Office of  
Environment  
& Heritage

DOC17/153023  
SSD 8175

**Notice of Exhibition - Western Sydney Stadium Stage 2 Design and Construction (SSD 8175)**

## **ATTACHMENT 1 – Office of Environment and Heritage comments on Western Sydney Stadium Stage 2 Design and Construction (SSD 8175)**

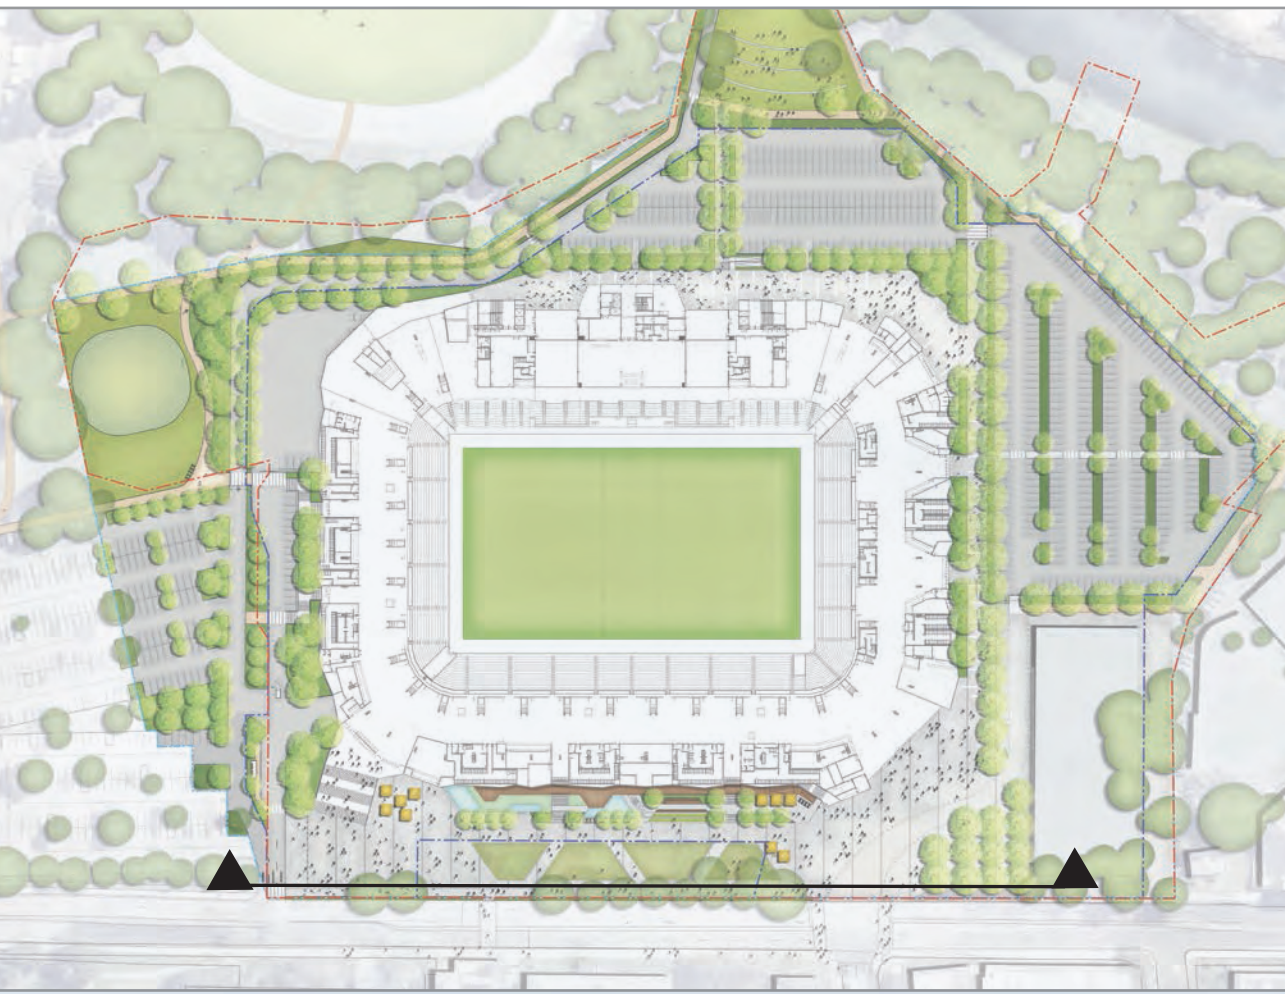
- There appears to be no provision for covers over the car park. OEH recommended covers over the car park to prevent faecal matter damaging cars, in our submission on the Concept Plan (19 August 2016) and reiterated the recommendation in comments on the RTS report (6 October 2016). To reduce future conflicts, OEH again recommends that such covers are provided, at least in the northern car park.

Figure 3 - Catchment Scale Pre-development 1% AEP Regional Flood Inundation

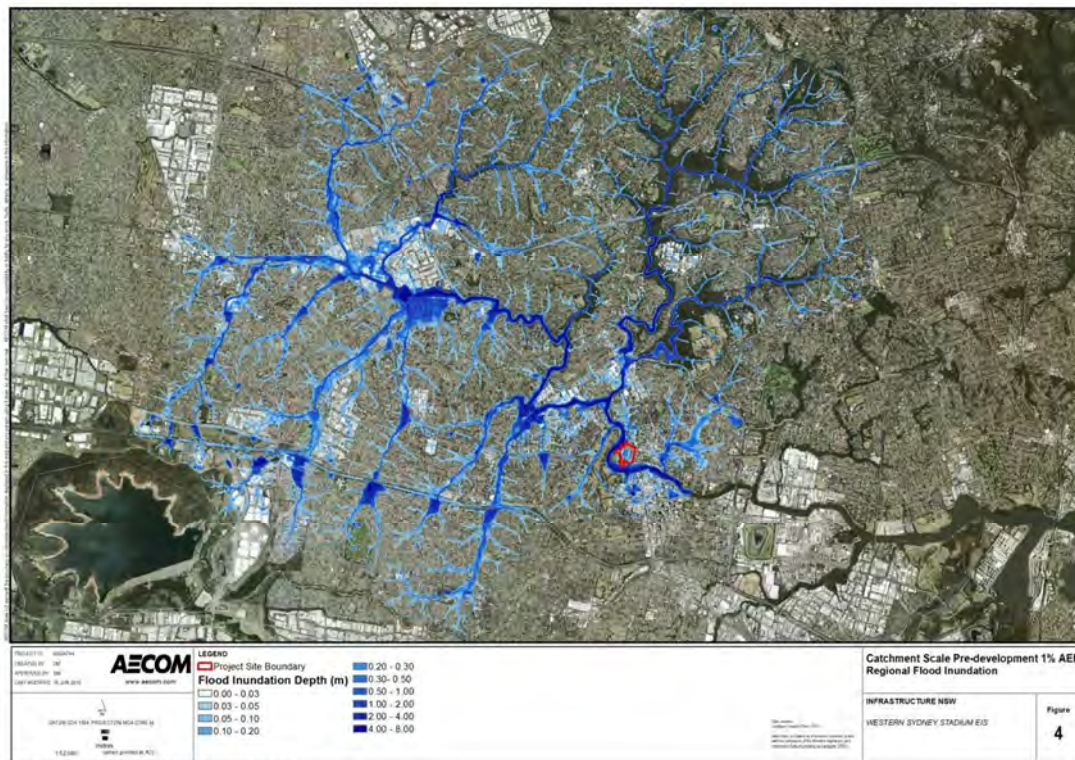
The March 2017 SMP report is a far simpler and less detailed report than the Flooding Working Paper (AECOM, July 2016) provided during the Concept Plan Exhibition with the following inconsistencies:

- AECOM (2016) states that the new stadium will include mitigation works to prevent this inflow into the site during extreme runoff events whereas Aurecon 2017 concludes that on-site detention (OSD) is unsuitable for a flood mitigation system.
- AECOM (2016) identifies an evacuation route to Victoria Road is available during the PMF or alternatively, the stands within the stadium are elevated and would provide separation from the PMF water level whereas Aurecon 2017 does not address flood evacuation.
- Aurecon (2017) in Table 3 has modelled post development discharge from the stadium to the Parramatta River which is lower than AECOM (2016) modelled discharges without explaining the difference (see table below).

1% AEP Flood Event			
Storm Duration	AECOM (2016) Pre Development Discharge (m3/s) Table 4	AECOM (2016) Post Development Discharge (m3/s) - Unmitigated	Aurecon (2017) Post Development Discharge (m3/s) - Unmitigated Table 3
5 minutes	1.1	1.31	0.494
10 minutes	1.35	1.59	0.981
15 minutes	1.38	1.7	0.494
20 minutes	1.42	1.85	0.981
25 minutes	1.4	1.75	1.305
30 minutes	1.37	1.71	1.303
1 hour	1.27	1.67	1.368
3 hours	0.98	1.49	1.411

Therefore, OEH considers that the SMP report (Aurecon, 2017) does not adequately address the SEARs (17 January 2017) and that there is inadequate detail provided to determine the flood risk from this proposal.
